Planning Application: P/49/21/RES

Location: Land North of Sefter Road & 80 Rose Green Road, Pagham

Description of works: Application for the approval of Reserved Matters pursuant to condition 1 (Reserved Matters details), condition 6 (Design Code Masterplan) & condition 7 (landscaping & layout details) following the grant of P/134/16/OUT for the erection of 250 No. dwellings, (including affordable homes), replacement scout hut, land for an Ambulance Community Response Post Facility, demolition of No. 80 Rose Green Road & provision of Public Open Spaces including associated children's play areas, landscaping, drainage & earthworks (resubmission following P/24/20/RES). This site also lies within the parish of Aldwick.

Drawing Title: Surface Water Drainage Strategy Layout

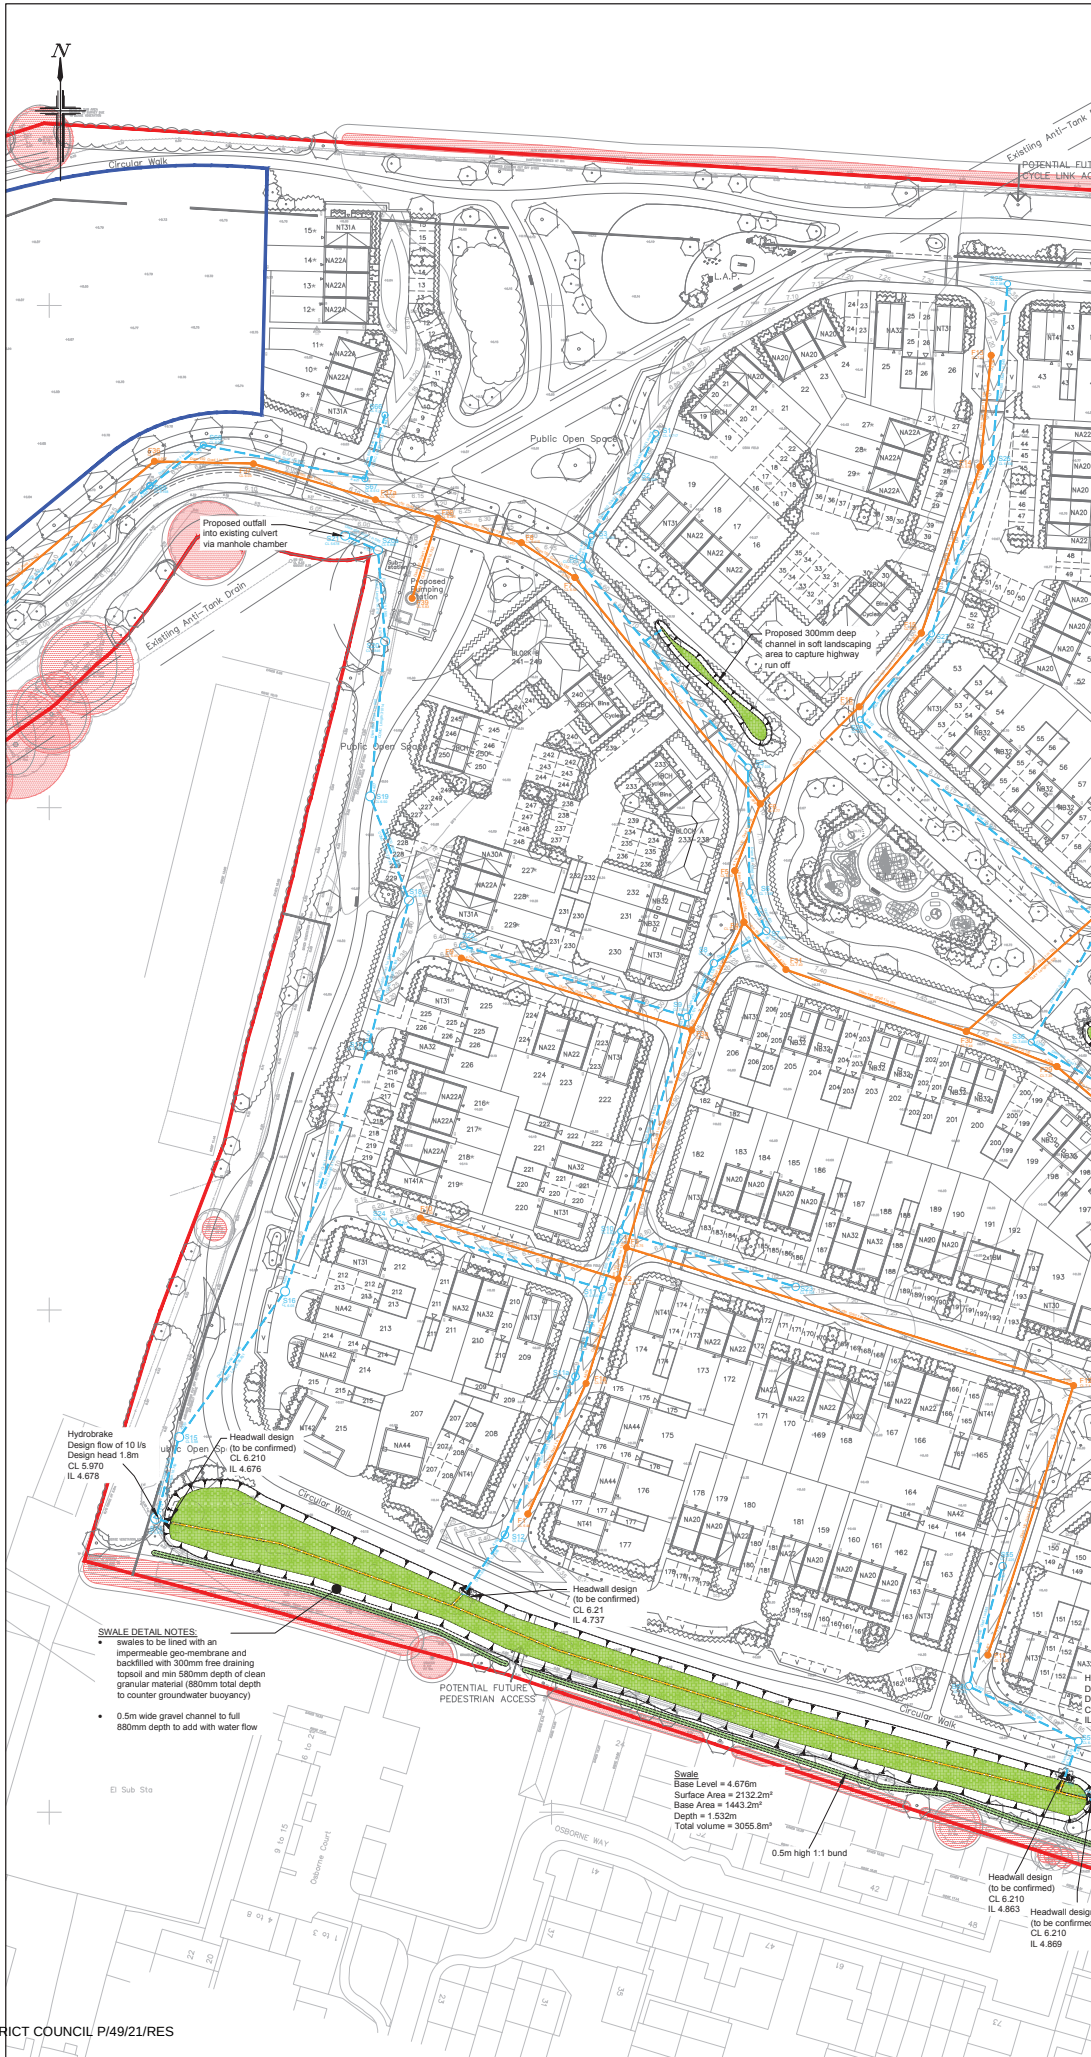
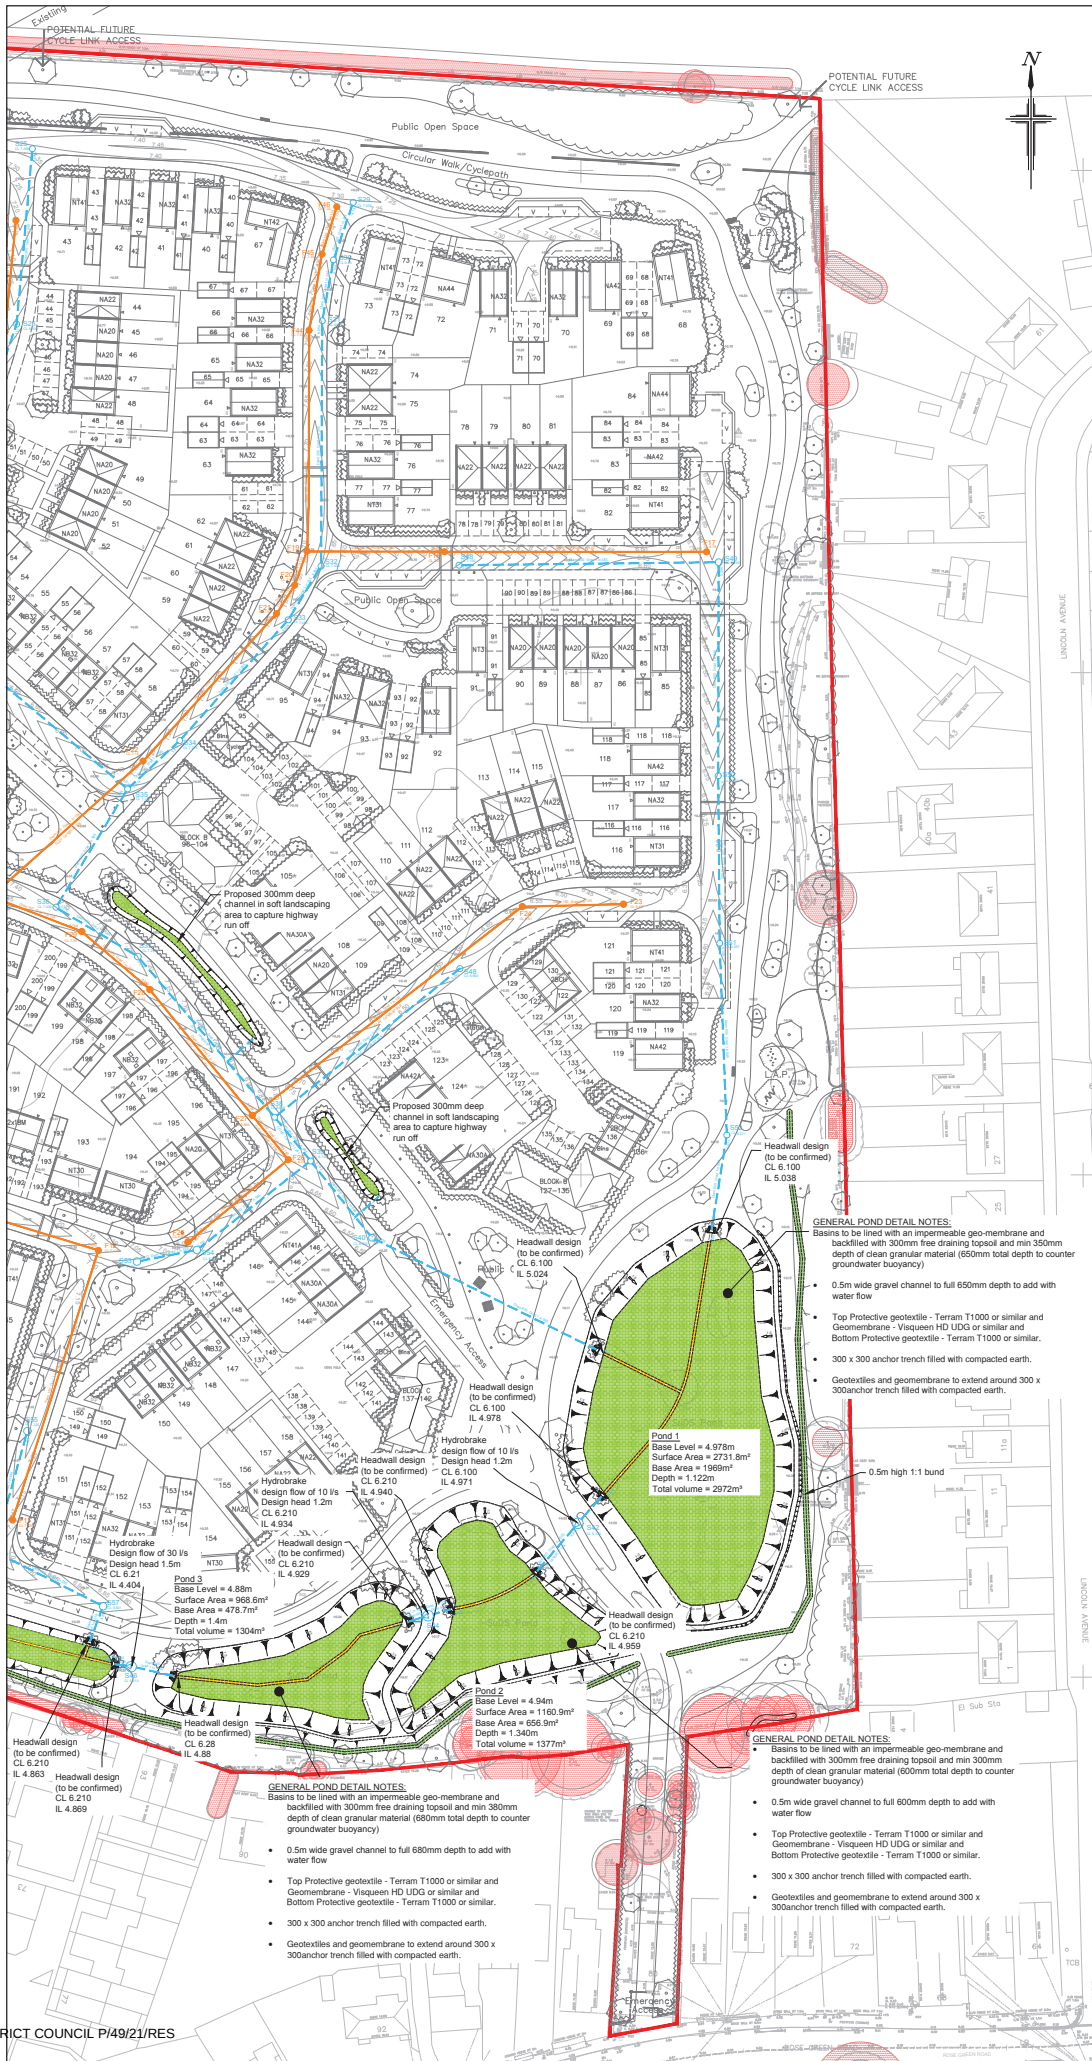
- There are significant trees around the site, many worthy of retention and some of which enjoy statutory protection TPO/P/4/19. Whilst the Landscape Masterplan, dwg. no. CSA/2038/140 Rev B appears sympathetic to their long-term presence I am concerned that surface water drain/ditch enhancements may have an adverse effect on their long-term health, especially where in proximity to preserved trees (Keen ref. T9, T10 and T45-62 incl.).

- There is not yet an approved surface water drainage strategy for the site. This fundamental element of the design ought to be addressed to our satisfaction in association with layout proposals, so that we are not subsequently held hostage to flood mitigation measures which could then impact heavily on retained trees/open space provision/landscape plans.

- I draw attention to the nominal root protection areas (RPA) of retained trees and their growth potential as obvious constraints to the siting of any SUDS (e.g. attenuation pond) or introduction of subterranean utility apparatus.

- Any improvements to existing or creation of new watercourses within the RPA of preserved trees (e.g. anti-tank ditch) to be avoided where practical and reasonable to do so. Where there is a significant risk of damage to higher value trees arising from such operations, then an alternative strategy should be proposed.

- Assurances are required around the extent of any future surface water drainage operations and associated working methods, in proximity to retained trees.
